CITY OF ALBUQUERQUE

December 3, 2019

Re: Tiny Homes
105 Texas St SE Albuquerque, NM 87108
Traffic Circulation Layout
Engineer's/Architect's Stamp 10-30-19 (K19D138)

TITLE
**TRAFFIC CONTROL LAYOUT
PROPOSED CONDITIONS**

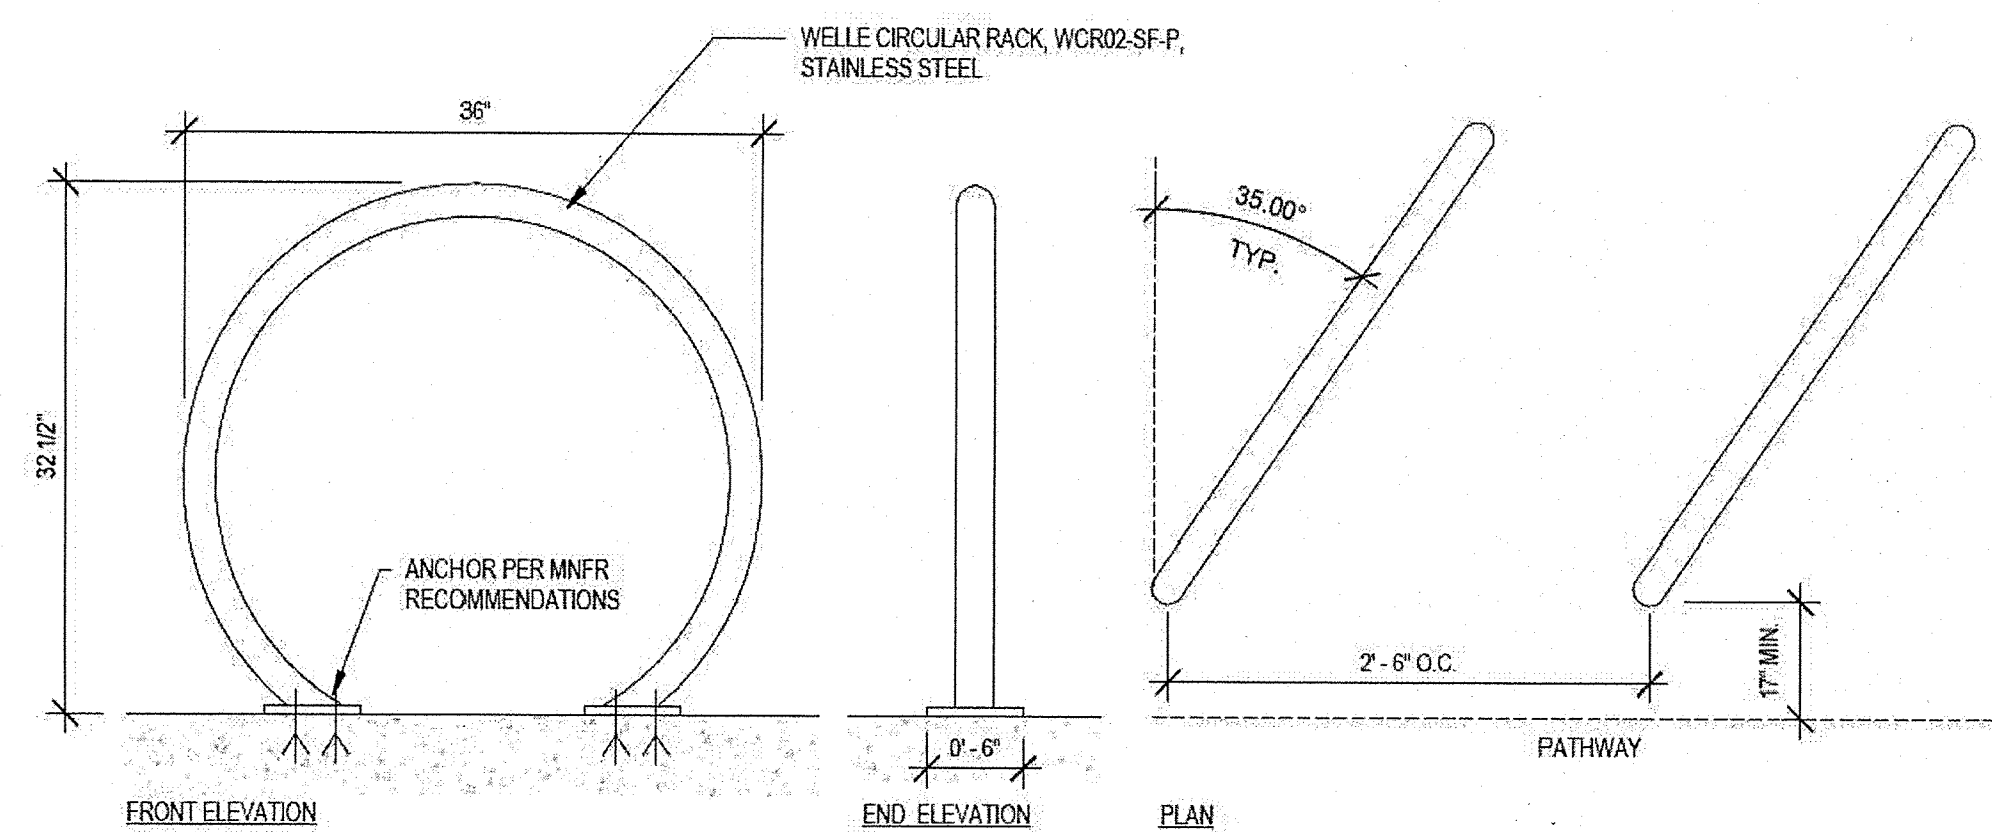
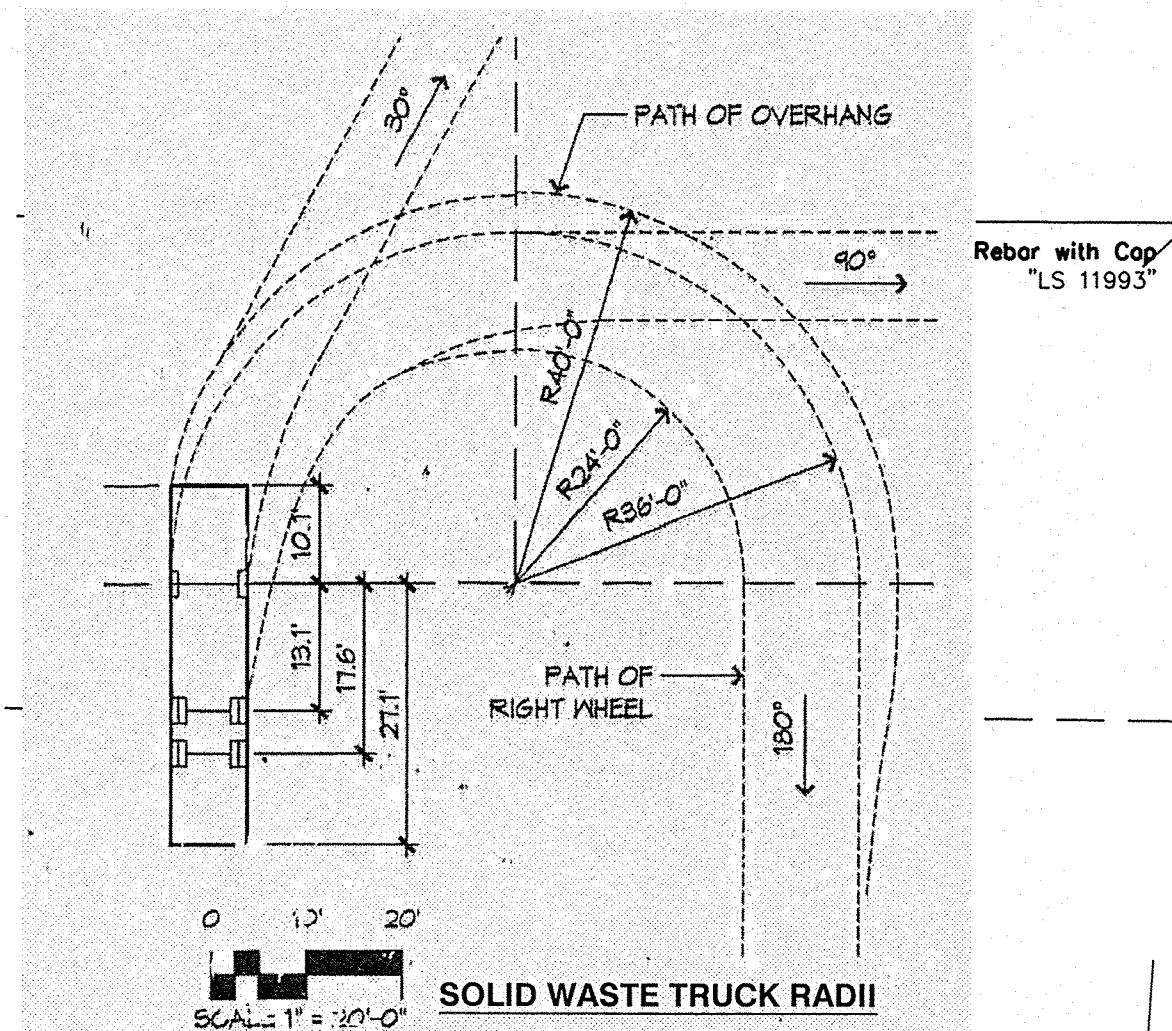
1. The parking table shows 29 spaces, but there are 27 spaces on the plan.
2. Refuse container seems to be very close to the parking space in the existing AIC parking lot. Please remove one of the spaces.
3. Refuse vehicle maneuvering shall be contained on-site. The refuse vehicle shall not back into the public right of way.; **provide a copy of refuse approval.**
